From: Andrew Wood [REDACTED]
Sent: 03 December 2019 09:35
To: Planning.Responses [REDACTED]
Subject: RE: email to Parish Council 25 November Minor Amendments Lanes End WA/7/19/RES

Subject: email to Parish Council 25 November Minor Amendments Lanes End WA/7/19/RES

Further to our recent exchange of emails and your email to the Parish Council 25 November re Minor Amendments I have the following comments to make

Comments on Option Unit 6

PJ DEVELOPMENTS LTD 2 Square Chambers 23 High Street Emsworth PO10 7AQ Tel: 0843 289 3430 Email: enquiries@pjdevelopmentsltd.com	
PROJECT: FORMER LANES END	
SITE PLAN OUTLINE PLANNING APPLICATION	
DATE: JANUARY 2019	DWG. NO 19-001 PL02
SCALE @ A1: 1:200	
REV: C

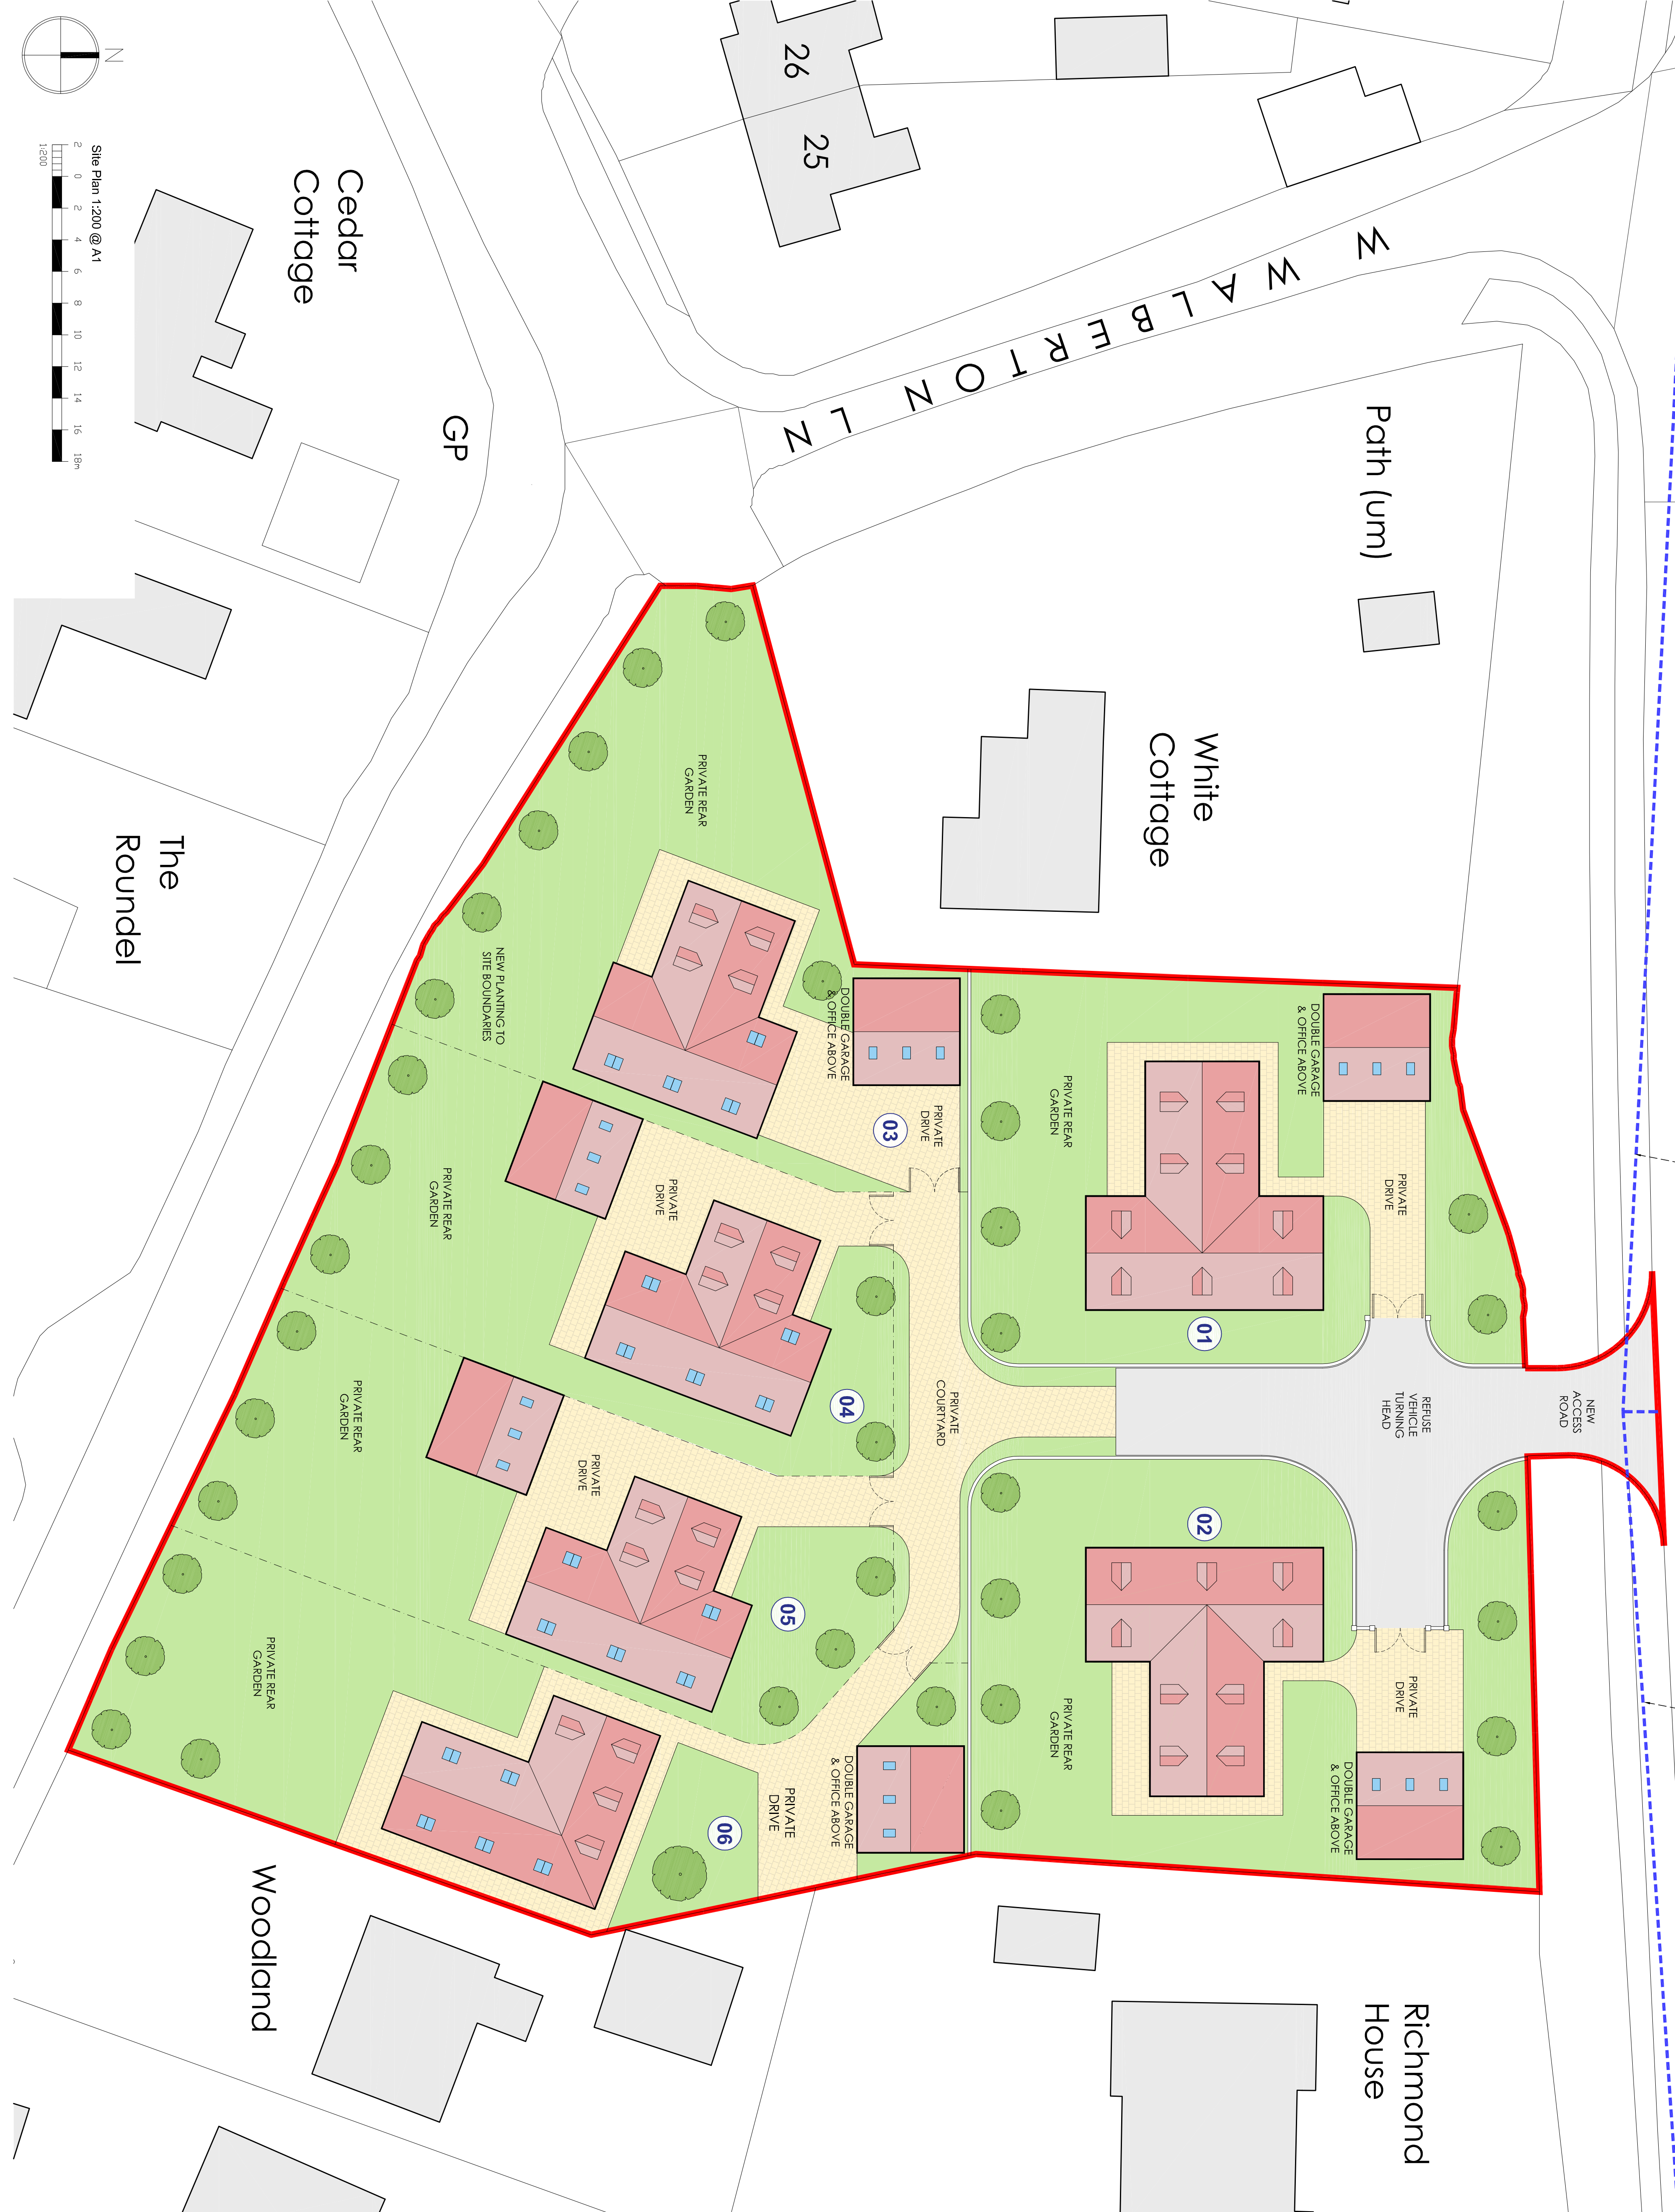
1. The view from Woodland would be badly affected. The existing Lanes End house is c40 metres from the boundary, but the unit 6 is less than 5 metres.
2. The size and closeness of unit 6 would mean a major loss of natural light in Woodland, our house, and would cast a large shadow over Woodland, its patio, conservatory and gardens on sunny afternoons
3. Most unit 6 windows will probably be on the wall facing Woodland, and more than on previous plans. These windows should be obscured glass and non-opening, to protect privacy of Woodland occupants.
4. Surface water run-off from the building will have an immediate effect on Woodland property.

1. The moving of unit 6 south from the outline plan position to the now proposed position shortens the garden length, and will badly affect its use as there are 2 trees with TPOs at the southern end of the plot.
- 2 Being so close to Woodland house would mean a major loss of privacy in unit 6.

It would be better for everyone to move unit 6 further North and turned slightly as shown on attached drawing A&V dated 1.12.2019 – nearer the position in the approved outline Block Plan. This removes most overlooking and privacy loss in both directions.
